**RE:** Starbucks and T-Mobile  
Lot 3B and 4A Krania Subdivision  
Grading and Drainage Plan  
Engineer's Stamp Date 3-9-2017 (File: K09D031C)

**RE: Revised Grading Plan (K09-D031C)  
Starbucks and t-mobile  
Albuquerque, New Mexico**

ENGINEER'S SEAL		STARBUCKS/ T MOBILE	DRAWN BY WCWJ
		GRADING AND DRAINAGE PLAN	DATE 12-13-16 21645-LAYOUT-12-05-16
12/12/16		<i>Rio Grande Engineering</i> 1606 CENTRAL AVENUE SUITE 201 ALBUQUERQUE, NM 87106 (505) 872-0998	SHEET # -
DAVID SOULE P.E. #14522			JOB # 21645

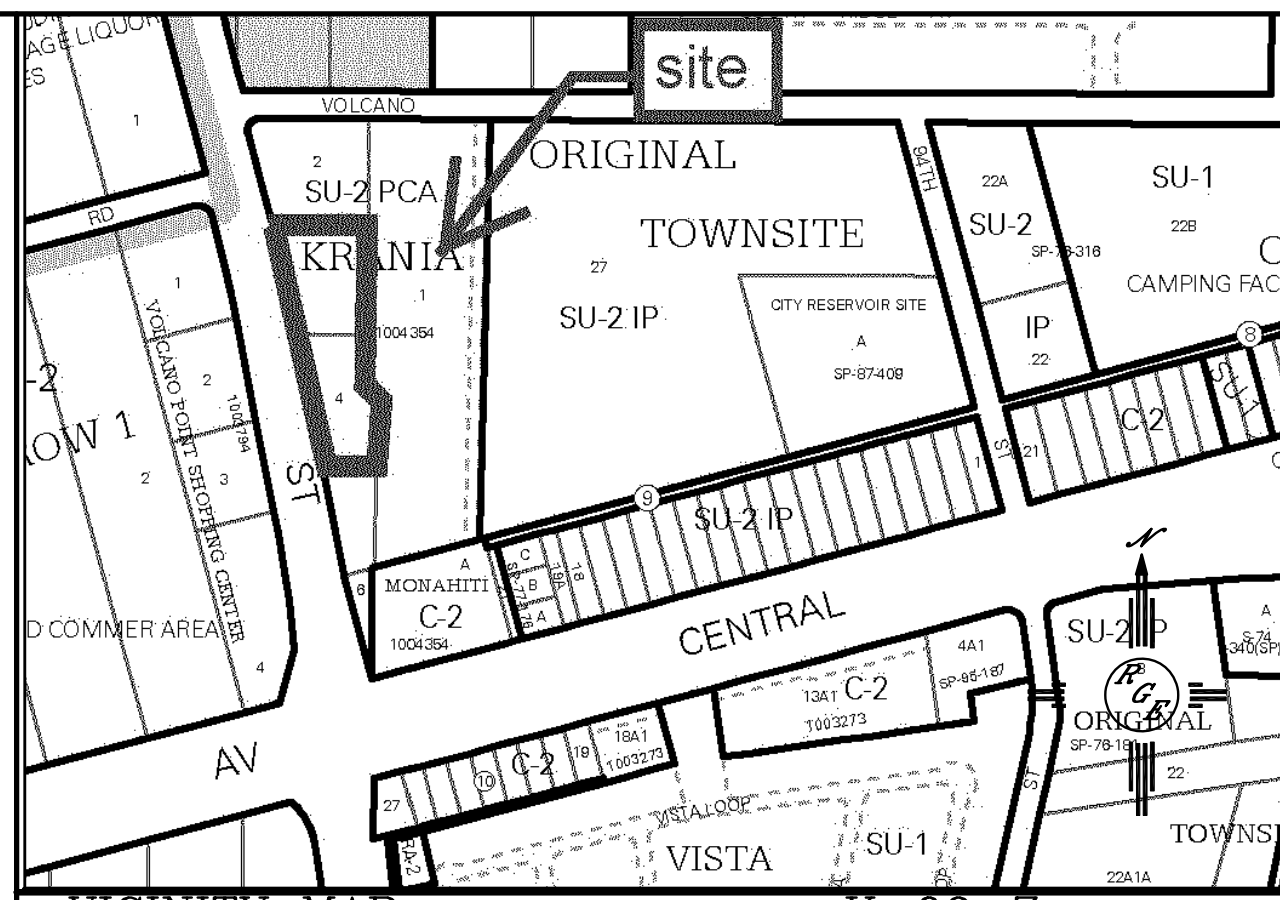
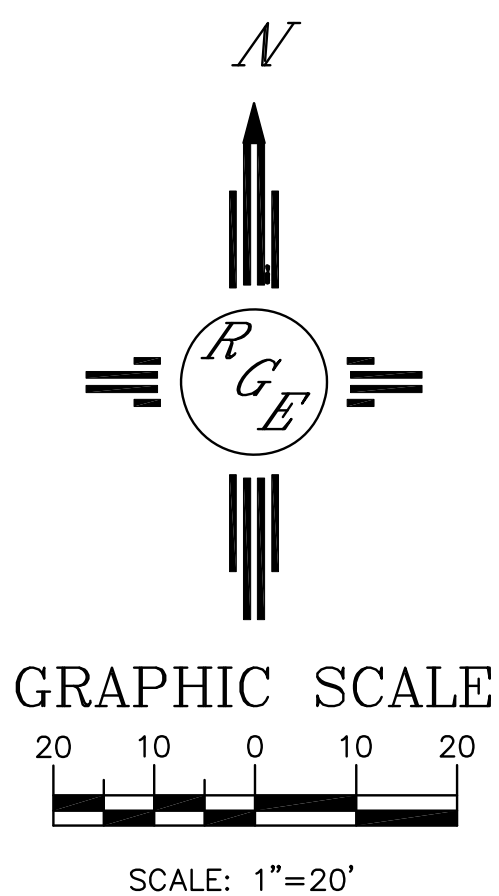
1. Drain must go to grease trap

2. T-mobile trash enclosure does not need drain

3. Provide Cross access and drainage easement.

4. Provide documentation on free discharge.

**We have added this note.**

**We have removed the drain.**

**We placed a red box around the verbiage on the plat dedicating the drainage easement. The placement of the note adjacent to dimension leaders for the sewer easement are confusing, but the lots have cross lot drainage, access and parking as shown on plat.**

**This is a pad site of the Krania subdivision. The developed condition assumptions are located in File K09/D031. As shown within the drainage report by Ron Bohannan 10/18/06 this site is located in basin 5. The site is allowed to free discharge based upon 75% D and 25% B. The site impervious exceeds the 75% yet the depressed landscaped areas and first flush ponds are treated at type A since they don't discharge and the peak discharge is less than allowed**
